**Hampstead Residents CLG. (Ref:- Submission No 111/Case 314724)**

**Our submissions at An Bord Pleanála (ABP) Metrolink Oral hearing 21/2/24.**

ALBERT COLLEGE PARK INTERVENTION SHAFT. PLAN
SCALE 1:400

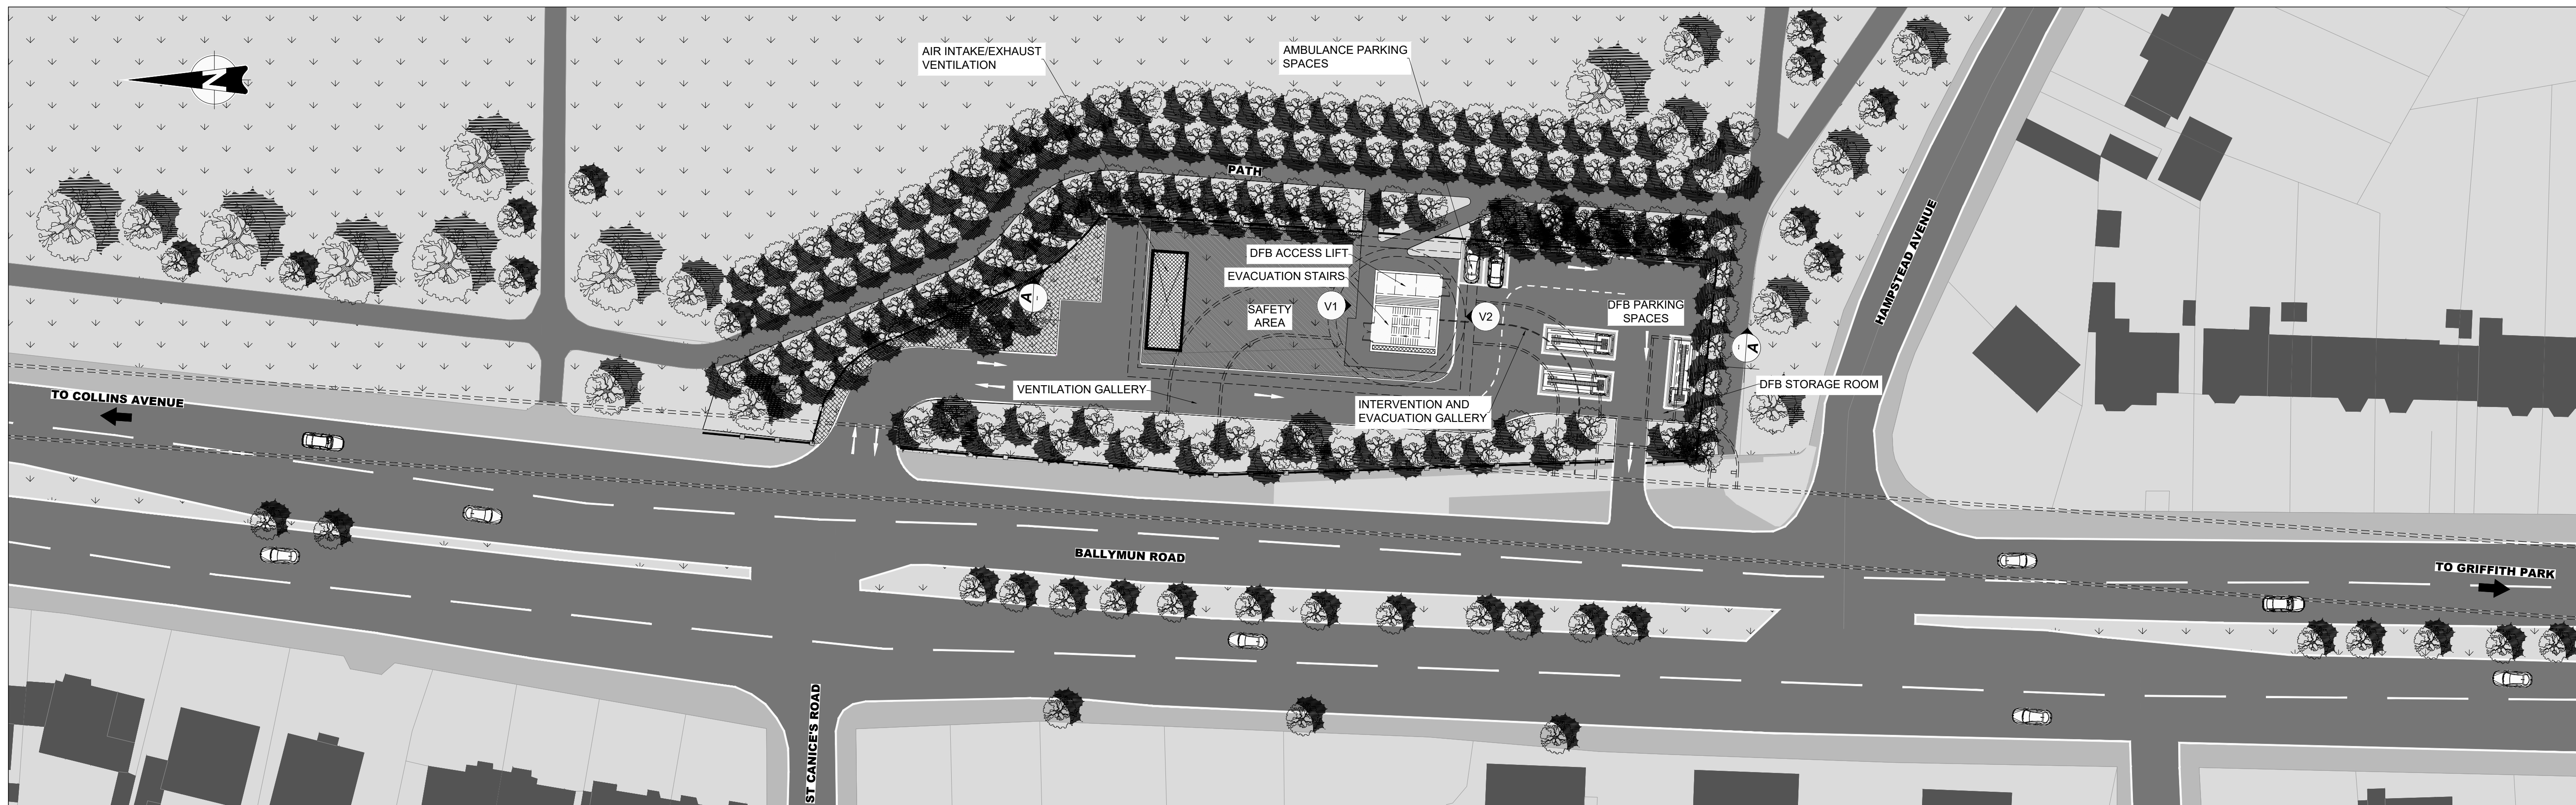
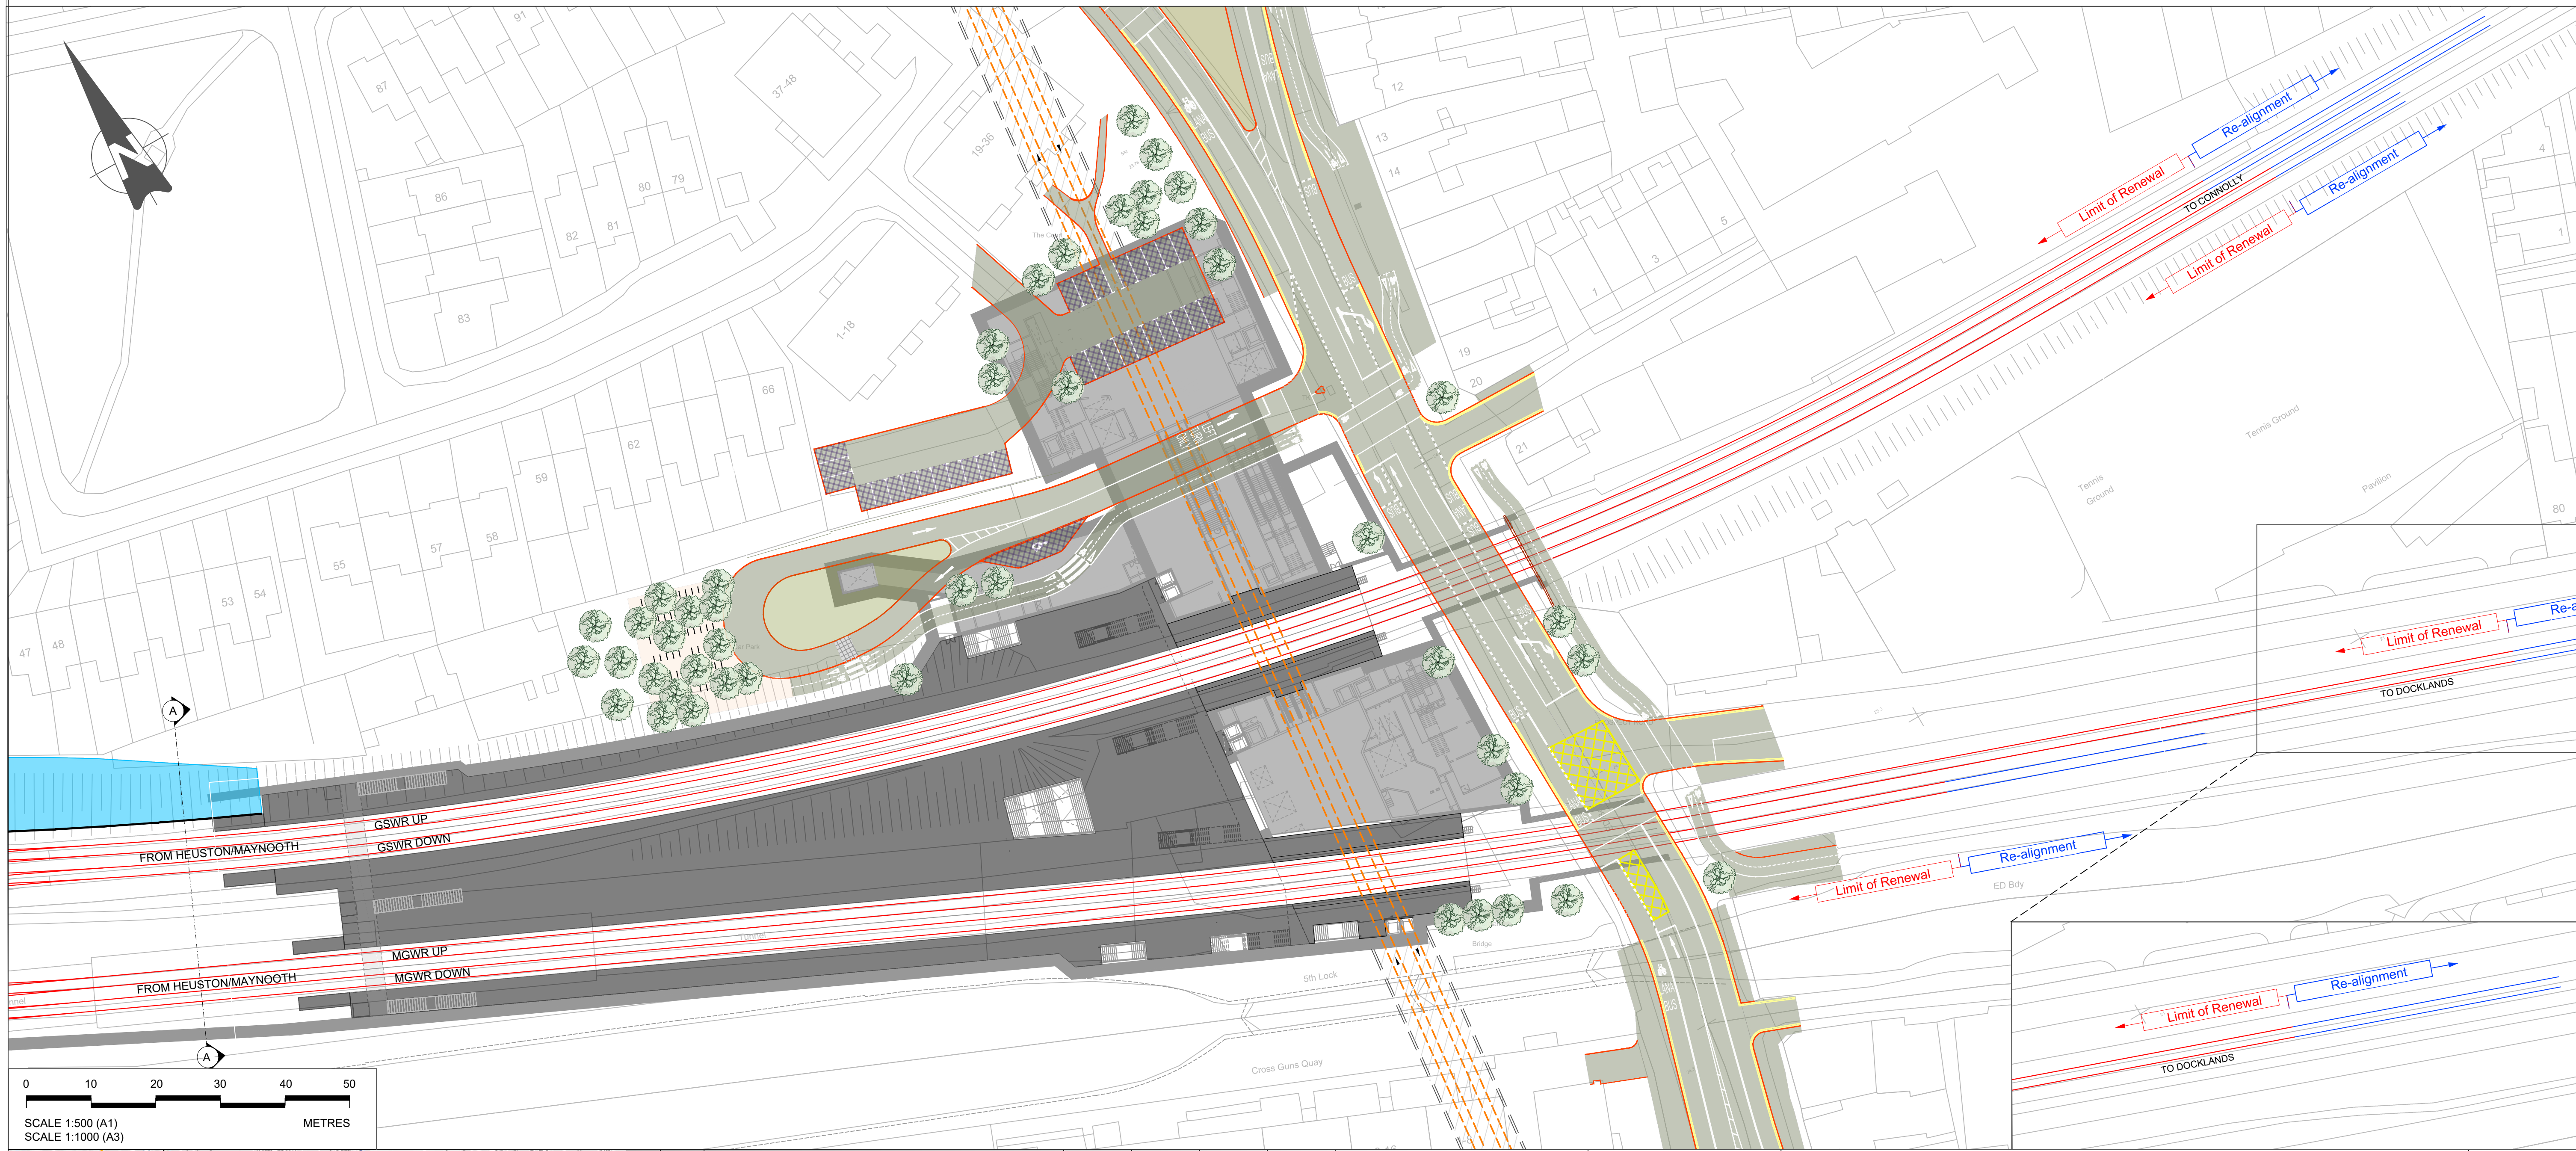
Within 20 meters of Hampstead Avenue, and in the south west corner of Albert College Park, a proposal by TII/NTA, is to position a large Metrolink **excavation and construction** site. This, at completion, will be the only combined 'Vent Shaft', Maintenance facility, Evacuation and Emergency access

TII/NTA have failed to address our Item No4 . This is related to the plan for a **large excavation site in Albert College Park.**

Our important point here is that 2 days before closure of the consultation phase (Emerging Preferred Route 'consultation' March-May 2019 ), there emerged from TII, new but critical **tunnelling/excavation** information. This was a 'hand drawn sketch' of a proposed intervention shaft, located in the South West corner of Albert College Park ,meters away from our residential area. :-

The importance of the 'sketch' of the proposed **excavation** in the Park was huge for our residents. It outlined, a large construction site on our doorstep, with NO associated local benefits for our residents or the wider community. We ask the inspector to investigate this, and the associated NO consultation.

TII/NTA have not directly addressed the fundamental issue that we have outlined several times in our submission :-No consultation occurred in relation to the actual existence of the proposed shaft. This shaft will bring with it huge **excavations, noise, vibration etc.** TII/NTA have presented no other ideas or alternative, for consultation.

Hampstead Avenue is located within 20 meters of one of the largest proposed construction and **excavation** sites on the entire Metrolink route. TII appear to have chosen to apply a distant sampling location as "applicable" to Hampstead Avenue.
